Subject: FW: Consultation on planning application 3/2012/0533 Lynbrook, Longsight Road, Clayton le Dale

The changes to this application compared with that previously approved on the site (Ref. No 3/2012/0187) do not raise any further highway implications. Therefore my comments are the same as before, as follows:

proposed site plan scale 1:200

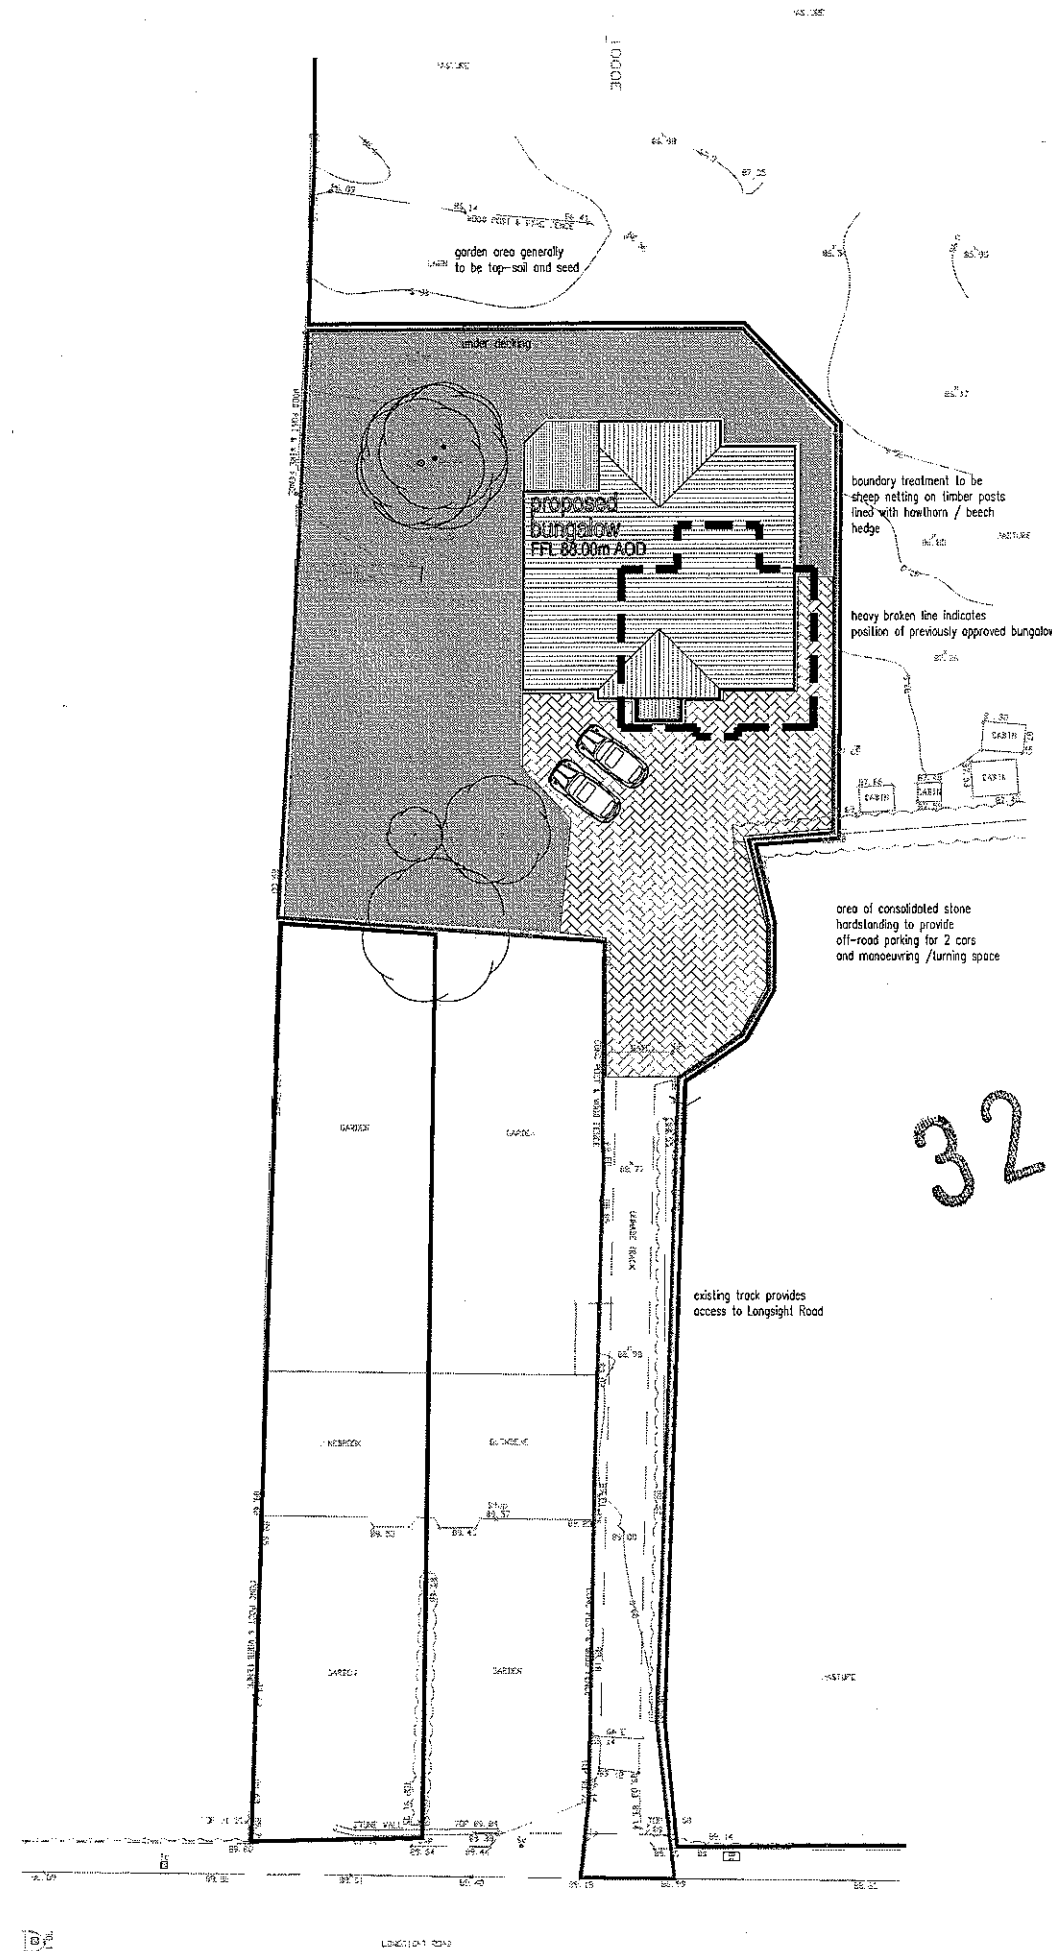
I am satisfied that an adequate visibility splay can be provided at the proposed access point, provided that the existing telegraph post adjacent to the driveway is moved back slightly and the hedgerow to the east is pruned back and kept suitably maintained. The proposed driveway already has the benefit of a dropped kerb and so no further engineering works will be required at the access to the highway.

1. Before the access is used for vehicular purposes, any gateposts erected at the access shall be positioned 5 metres behind the nearside edge of the carriageway of Longsight Road. The gates shall open away from the highway. Reason: To permit vehicles to pull clear of the carriageway when entering the site.

2. Before the access is used for vehicular purposes, that part of the access extending from the highway boundary for a minimum distance of 5 metres into the site shall be appropriately paved in tarmacadam, concrete, block pavements, or other approved materials. Reason: To prevent loose surface material from being carried onto the public highway thus causing a potential source of danger to other road users.

3. The vehicular parking and turning space shall be laid out as detailed on the submitted plans and be available for use before the development is brought into use. Reason: Vehicles reversing to and from the highway are a hazard to other road users.

The visibility splay to be the subject of this condition shall be that land in front of a line drawn from a point 2.4 metres measured along the centreline of the proposed driveway from the nearer edge of the carriageway of Longsight Road to points measured (a) 90 metres to the west along the nearer edge of the carriageway of Longsight Road and (b) 90 metres to the east along the centreline of the carriageway of Longsight Road, and shall be constructed and maintained at verge/footway level in accordance with a scheme to be agreed by the Local Planning Authority in conjunction with the Highway Authority. Reason: To ensure adequate visibility at the site access
